OFFICIAL NOTICE OF DECISION

Project# 1007836

09DRB-70203 MAJOR – SITE DEVELOPMENT PLAN FOR BUILDING PERMIT

TATE FISHBURN ARCHITECT agent(s) for FIRST BAPTIST CHURCH OF WEST ALBUQUERQUE request(s) the referenced/ above action for Tract H29A1, **RIVERVIEW SUBDIVISION**, zoned SU-1/ CHURCH, located on the northeast corner of LA ORILLA NW and GOLF COURSE RD NW containing approximately 6.7 acre(s). (E-12)

SDP-1

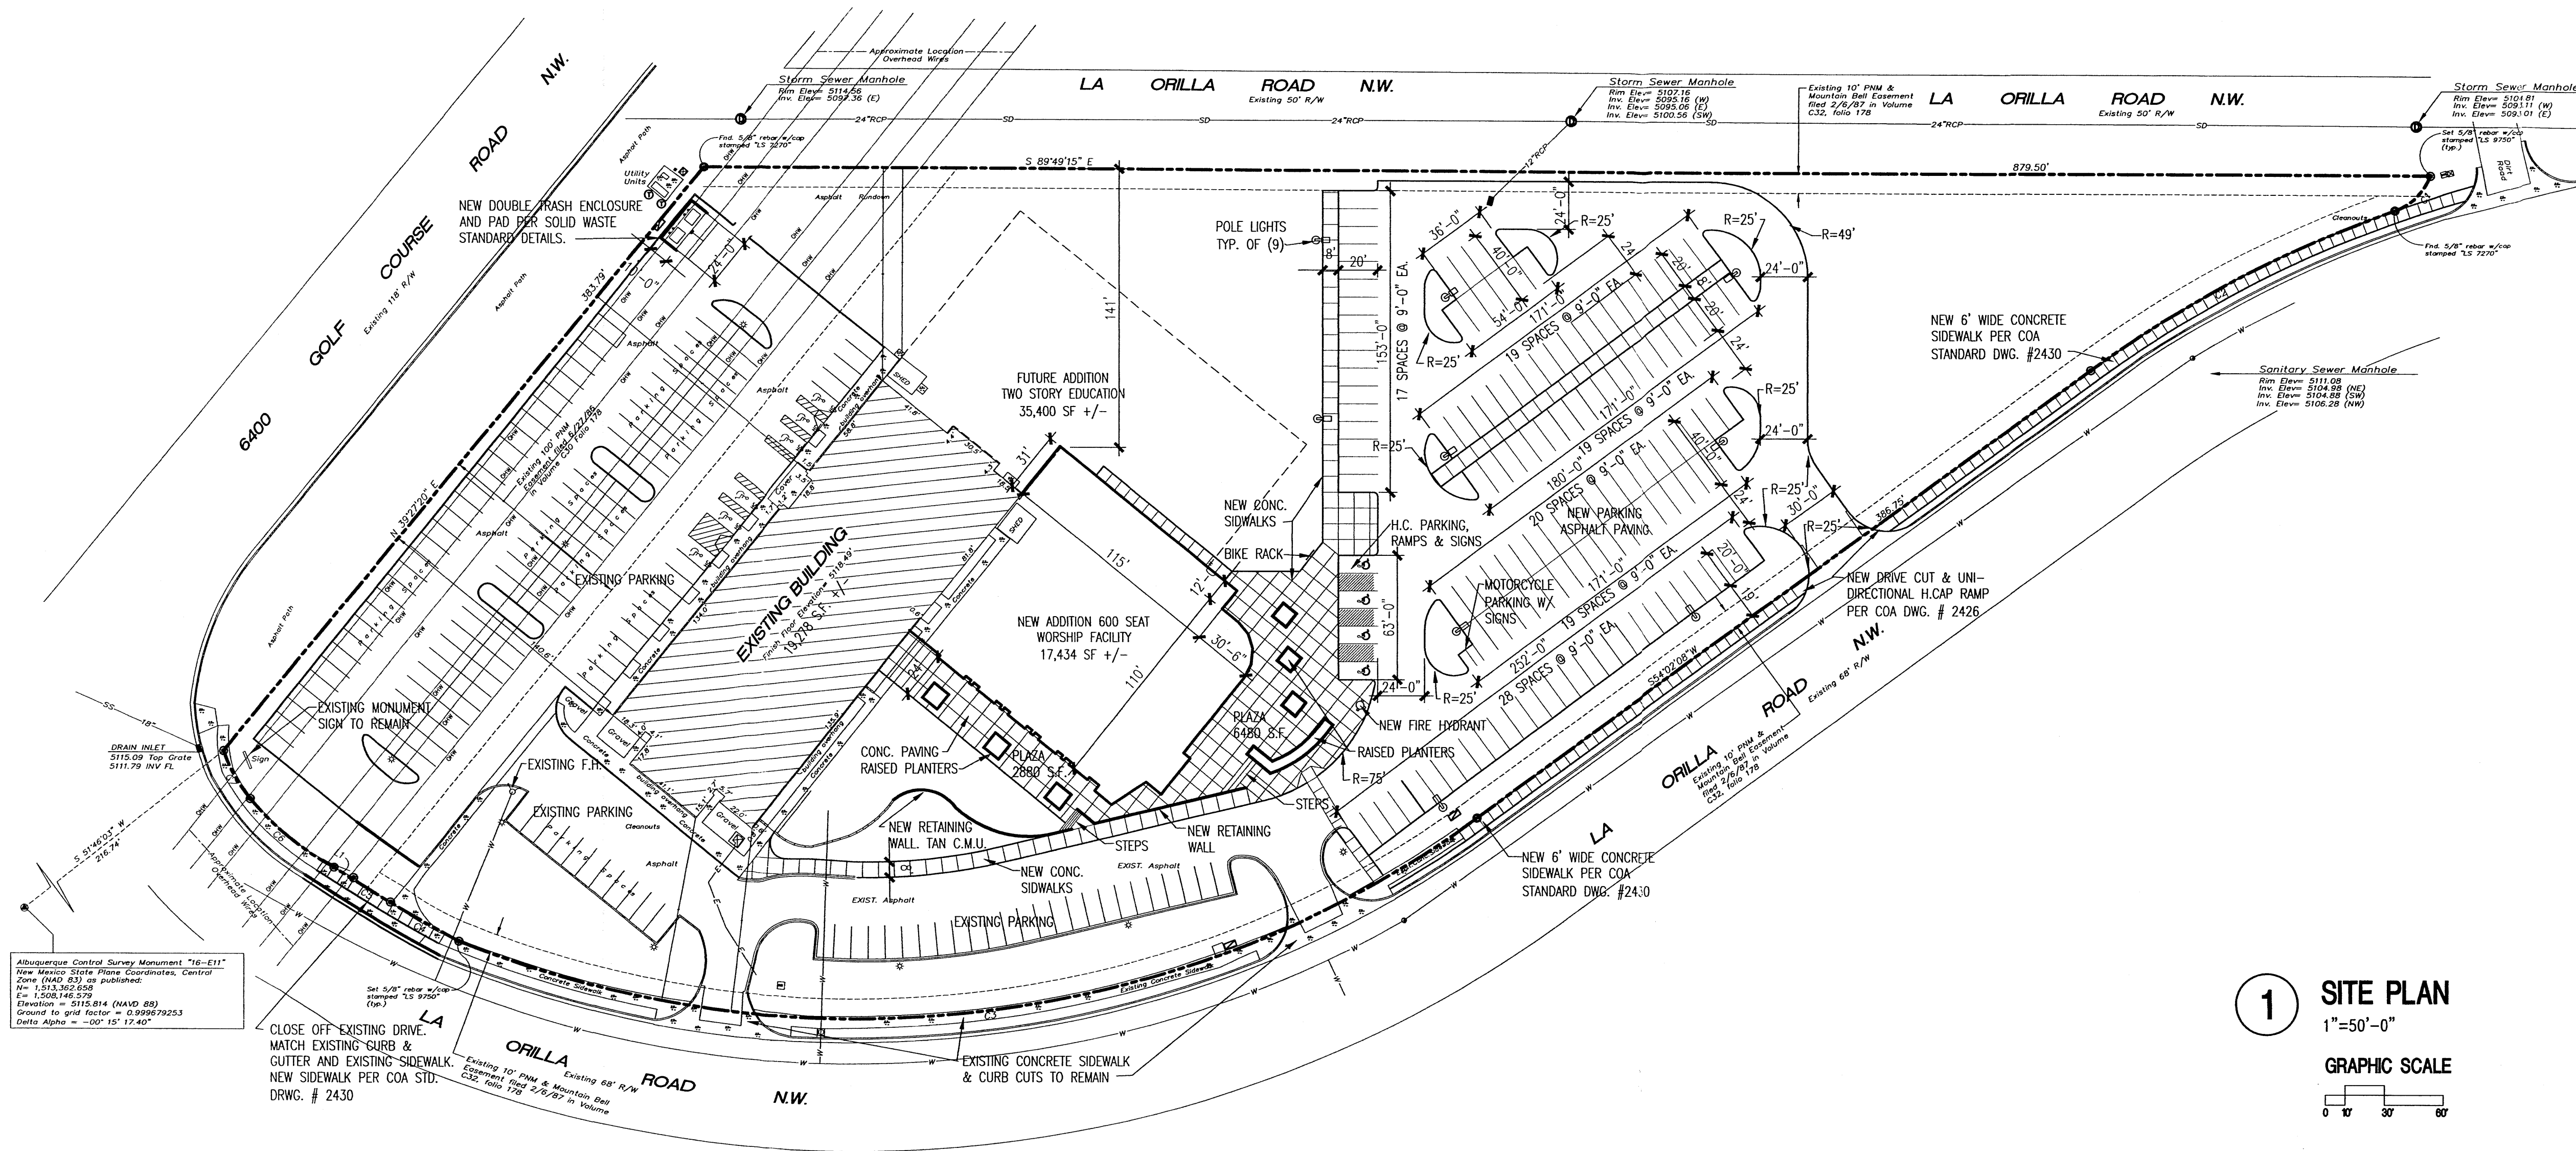
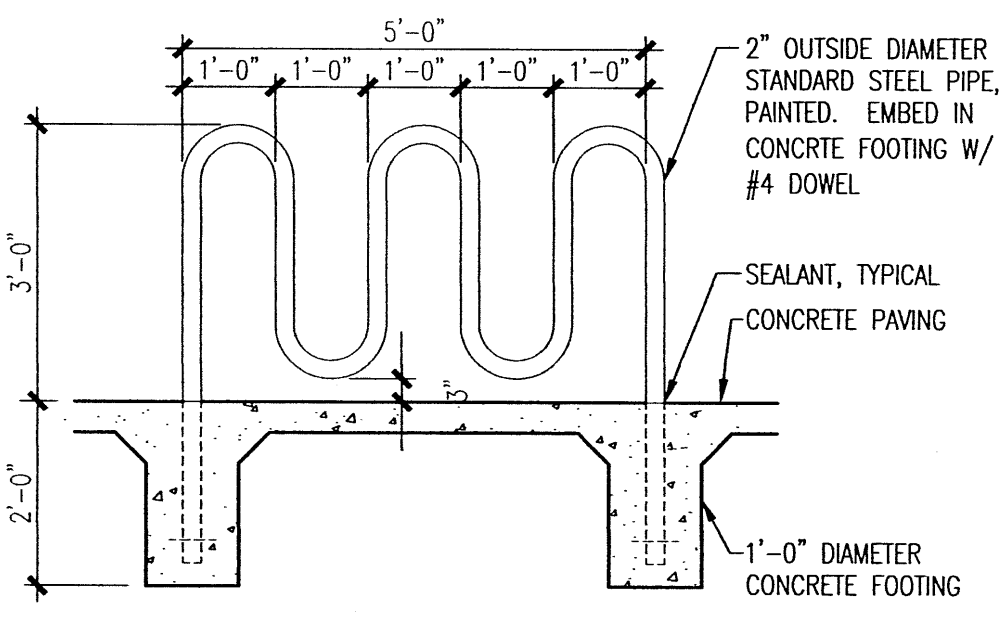
- 315 parking spaces provided maximum seating is 1260.
- Provide 6' landscaping along North & East side of parking lot.
- Light poles along east side if within 100' of residential 16' maximum height.

Call out the parking aisle width along the proposed addition.
All ramps located within the City right of way must have truncated domes.
Show all internal wheelchair ramps and provide details.
Call out the width of the pedestrian connection from La Orilla Road.
Clearly indicate the accessible path from the handicapped parking spaces to the building.

Comments from the Department of Municipal Development:
A 10-foot wide asphalt pathway is required along La Orilla Road (northern alignment) per the *Long Range Bikeway System Map*. This pathway must tie in to the path on Golf Course Road.
Clearly show the location of the existing asphalt trail along Golf Course Road NW.

Existing parking requirements need to be noted on the site plan (not just EXISTING SPACES PROVIDED).
Street trees should be installed with this phase for the remaining frontage on La Orilla Road.
